RIO GRANDE ENGINEERING OF NEW MEXICO, LLC

**RE: Grading and Drainage Plan
Beehive homes (L232-D022)**

The purpose of this letter is to accompany the enclosed grading plan for the referenced project. This plan has been modified to address your comments dated August 29, 2013. The following is a summary of your comments with the annotation as to how the plans were modified to address the comments.

BEEHIVE HOMES SITE DEVELOPMENT PLAN DETAILS Rio Grande Engineering 1606 CENTRAL AVENUE SE SUITE 201 ALBUQUERQUE, NM 87106 (505) 872-0889	DRAWN BY WCWJ
		DATE 3-02-13
		21227-LAYOUT-7-13-12 SHEET # 2 JOB # 21227

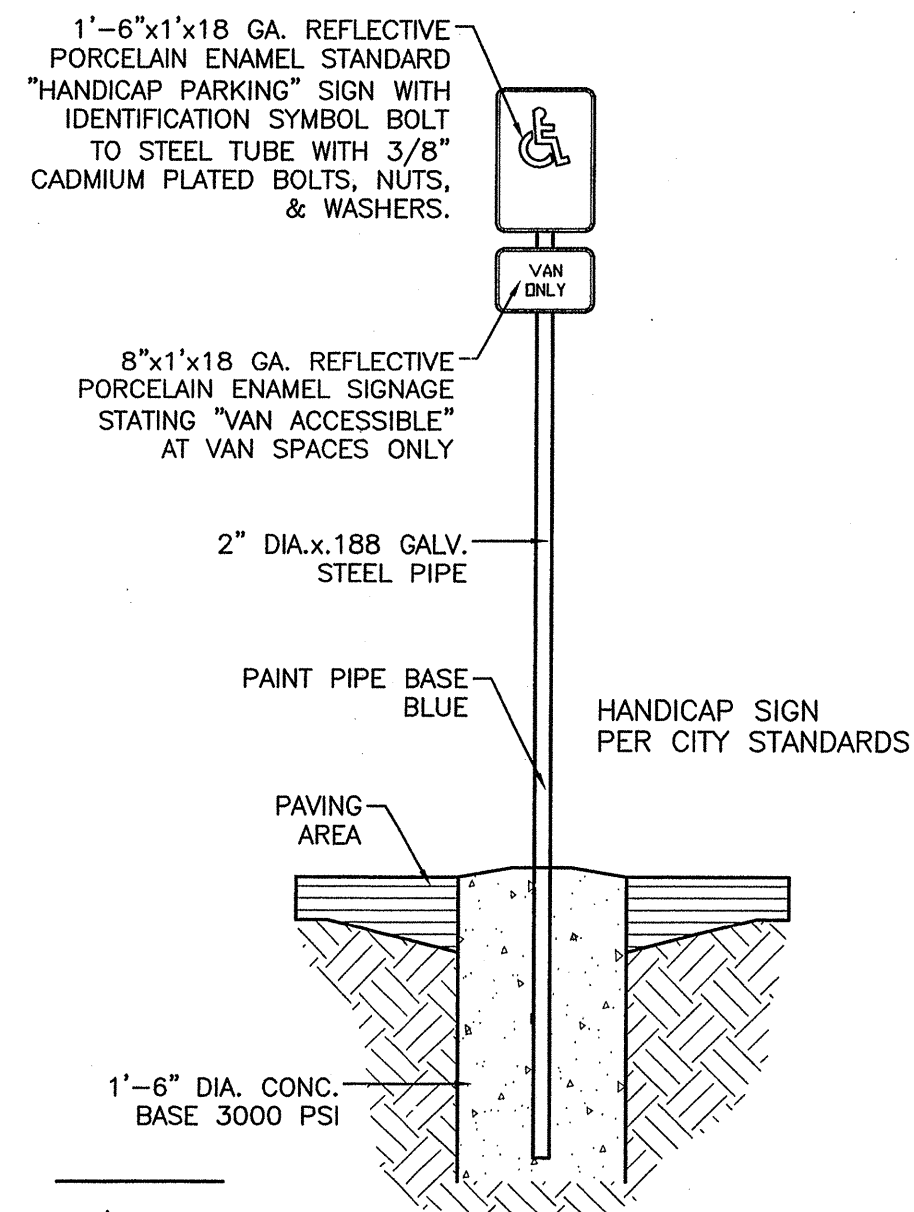
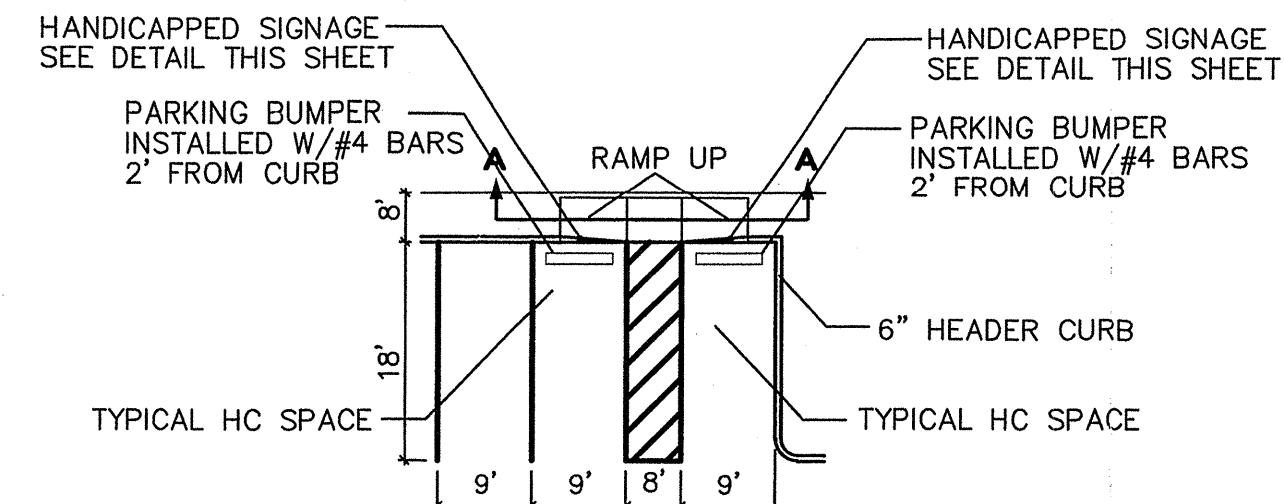
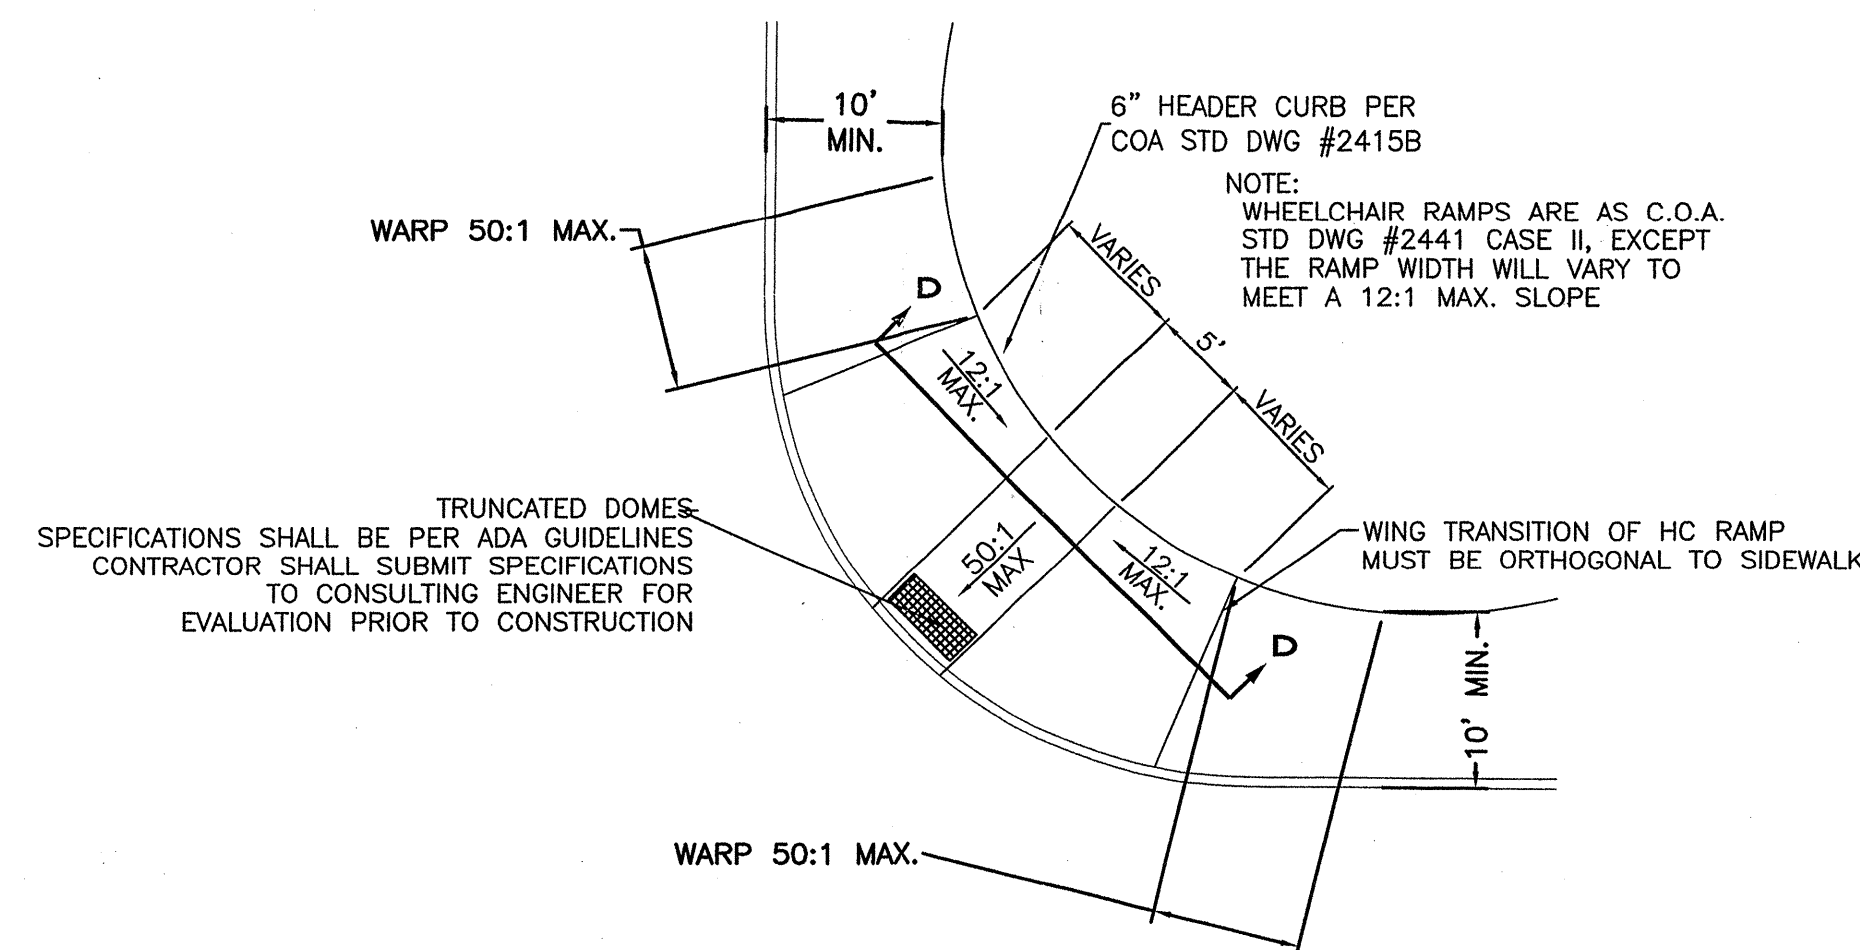
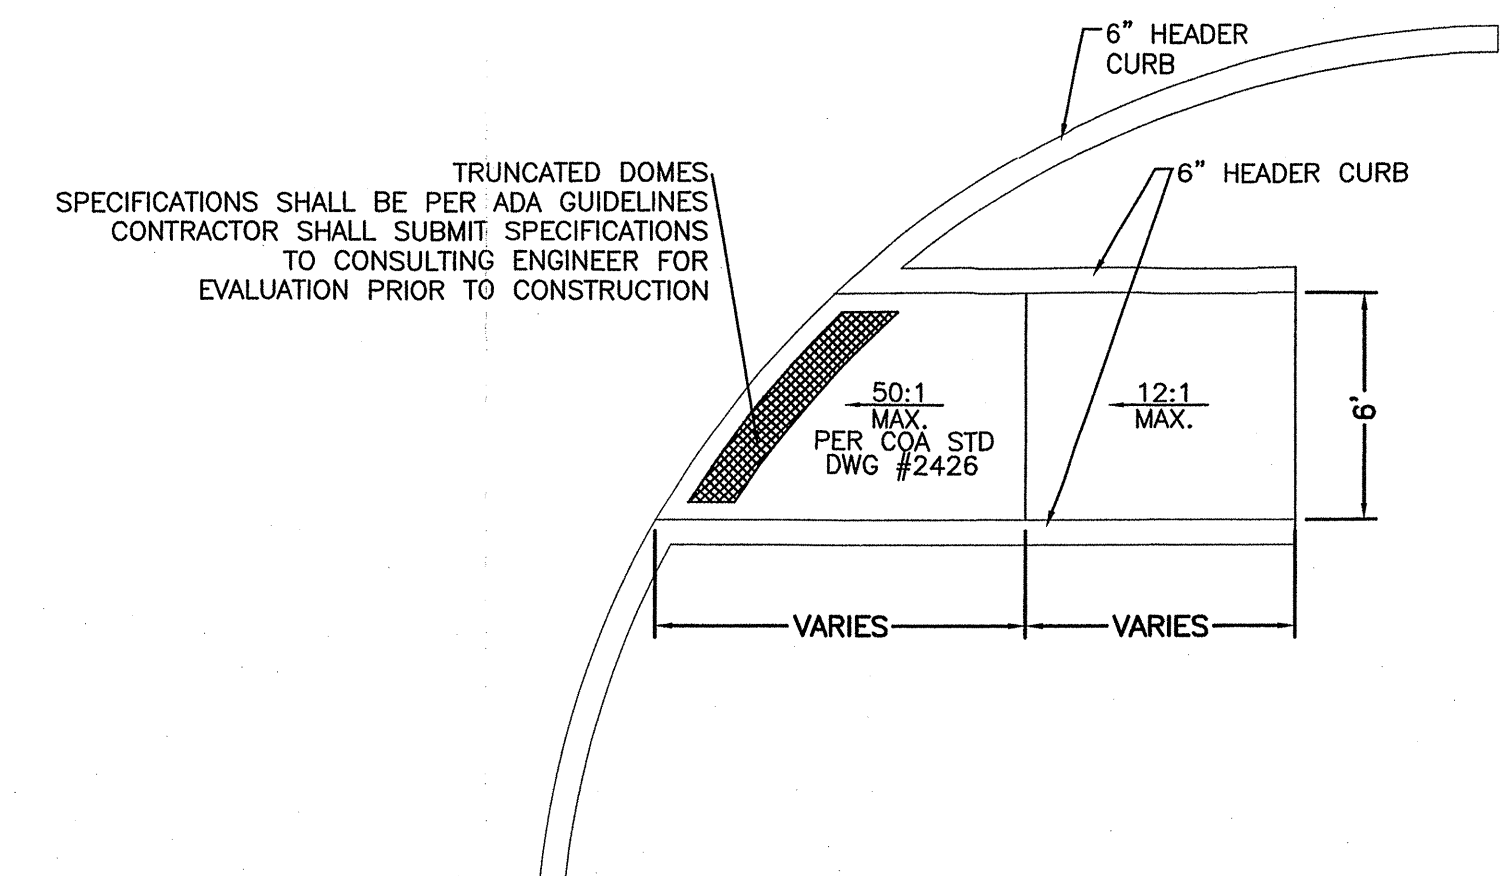
14. Details, sheet 2:

- A. Better define cobble swale
We have clarified the swale is to have 6" cobbles, 1' deep
- B. Correct section A-A
We have corrected this section
- C. Adjust section B-B
We have modified section to account for changes to wall
- D. Revise Emergency spillway detail per previous comments
We have adjusted
- E. Provide more detail on channel penetration
- F. **We have added more detail to better describe how penetration shall be constructed**

ENGINEER'S SEAL	BEEHIVE HOMES	DRAWN BY WCUJ
DAVID SOULE NEW MEXICO REGISTERED PROFESSIONAL ENGINEER 14522	GRADING AND DRAINAGE PLAN	DATE 10-02-13
	Rio Grande Engineering 1606 CENTRAL AVENUE SUITE 201 ALBUQUERQUE, NM 87106 (505) 872-0999	21227-AYOUT-7-13-12
		SHEET # 1
		JOB # 21227

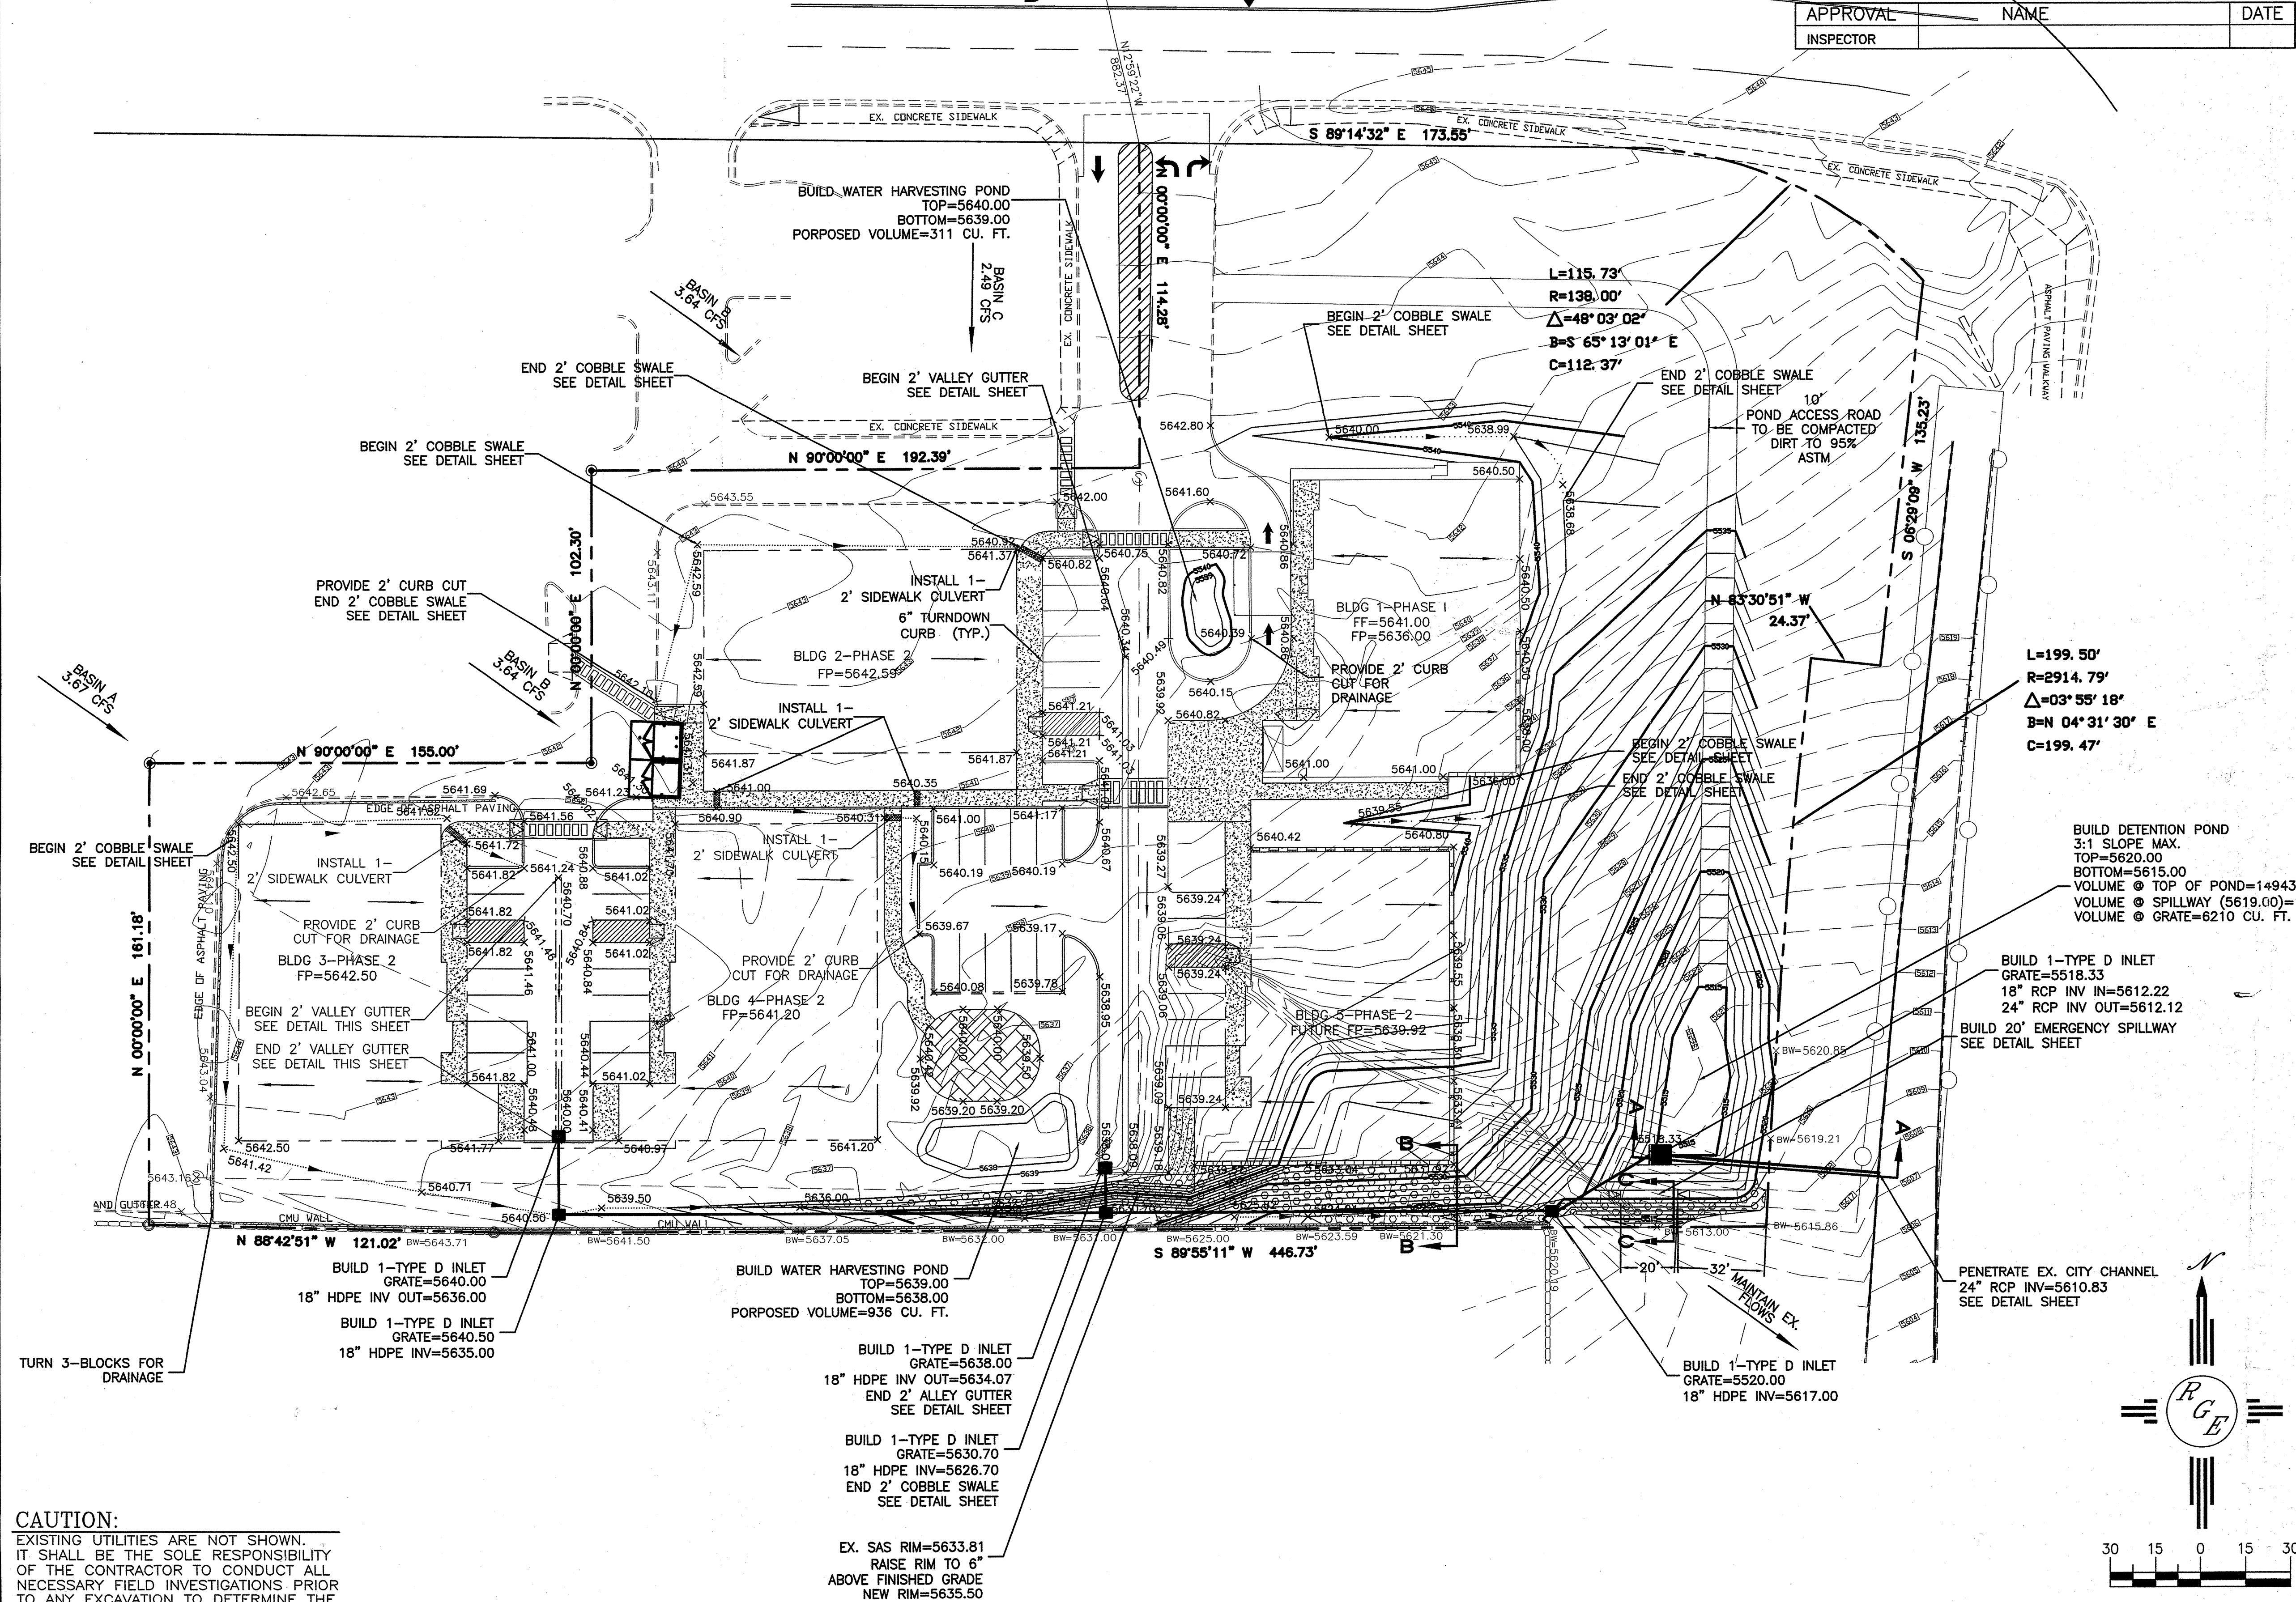
2. Drainage report discusses retaining first .44", yet plan shows releasing all flows
We had submitted in correct outfall elevation and have corrected
 - a. Storm drain pipe shall connect directly to channel
We have modified piping such the flow from the upland and majority of site drains directly to the channel.

- b. Pond will be resized to accommodate flow for undeveloped east side and rear roof areas.
We have reconfigured the pond to account for the flows from east side of lot the ponding is sized to contain the 100-year 6 hours volume and the inlet will release volumes in excess to the storm drain pipe and discharge to the channel.

- c. Raise grate on inlet to allow for retention.
We have raised the inlet to provide adequate volume for the first .44 inches and the 100-year 6-hour volume of the contributing basin

- d. Pond spill way shall correspond to existing flow path to south.
We have adjusted the spillway location.
 - e. Show how retention pond will be accessed.
The pond will have clear access from the north; the slope is 3:1 and will be able to be accessed from the site from the undeveloped area

3. Clarify how site "rough grading" is intended to be completed
The entire site will be graded at one time. We have specified pad elevations, the future homes are to be built with crawl space, and will be dug out at time of phase construction.

4. Label the building numbers and phasing
We have labeled the phasing and building numbers
5. What is purpose of wall on south side, eliminate the no mans land. Is south swale plated as well
We adjusted the retaining wall and removed screen wall. The swale is to be cobble per detail and callout

- d. What are limits for cobble swale, same pattern used.
All swales shown will be cobble
7. Add flow arrows and offsite design Q's. Show how they enter the site
We have added the flows and provided clear path for upland flows to enter the site.

8. Show where roof flows leave the structure
The roofs are pitched and leave roof as sheet flow.
9. Clarify inlet details on southern end. How will flows enter the inlet
We have added the curb to force water into inlet

10. Add sidewalk culverts so concentrated flow does not go over sidewalks
We have added.
11. Adjust swale at NW corner of western building pad
We have corrected.

13. Show SAS manhole and account for
We have shown manhole and addressed raising to 6" above finished grade
